Application No: A/136/20/PL
Site Address: Land North of Mayflower Way Mayflower Way Angmering BN16 4AY
Description of Works: Erection of 24 No. dwellings with garaging & open residential & visitor parking, new access from Mayflower Way, provision of hard & soft landscaping & open space, foul & surface water drainage systems & other works (resubmission following A/46/20/PL). This application is Liable as 20 new dwellings in CIL Zone 2.

To: Ecology Advisor

NOTIFICATION FROM ARUN DISTRICT COUNCIL

Figure 2. Phase 1 map of the Mayflower Way, Angmering site.

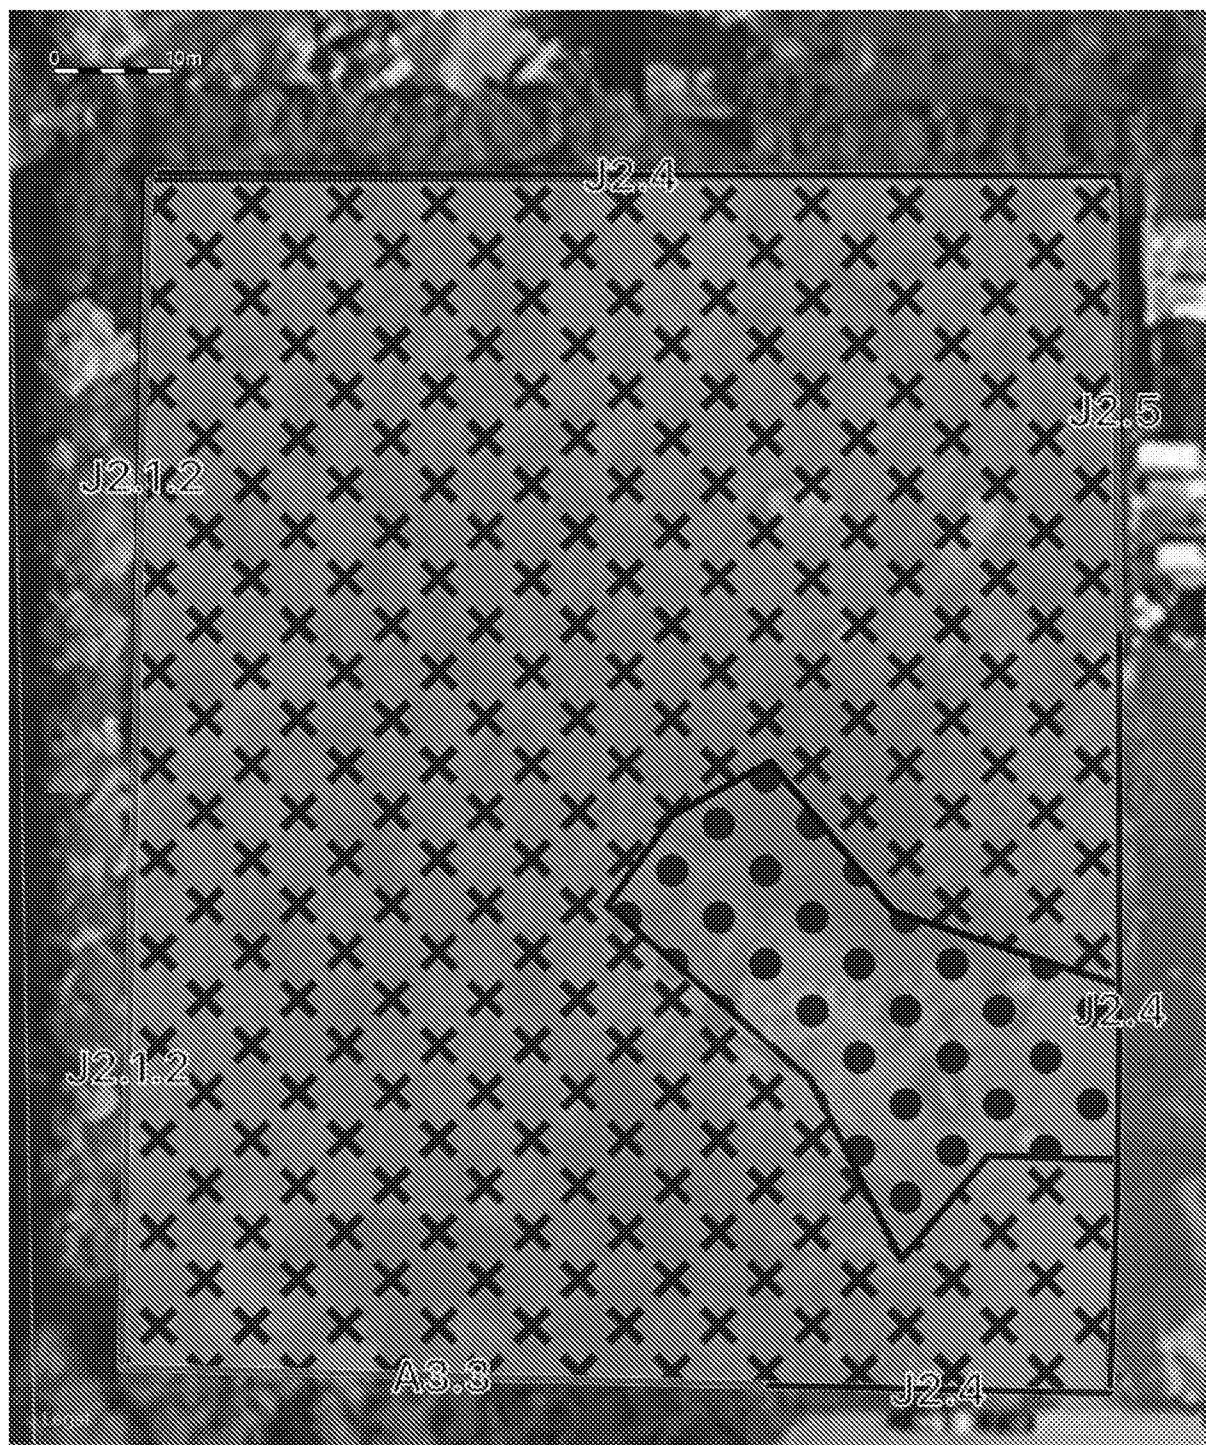
The hedgerows on site are used by bats for commuting and foraging and will need to be retained and enhanced for bats. This will include having a buffer strip around the hedgerows (5m) and during construction fencing should be used to ensure this area is undisturbed. Any gaps should also be filled in using native hedge species to improve connectivity. Conditions should be used to ensure this.
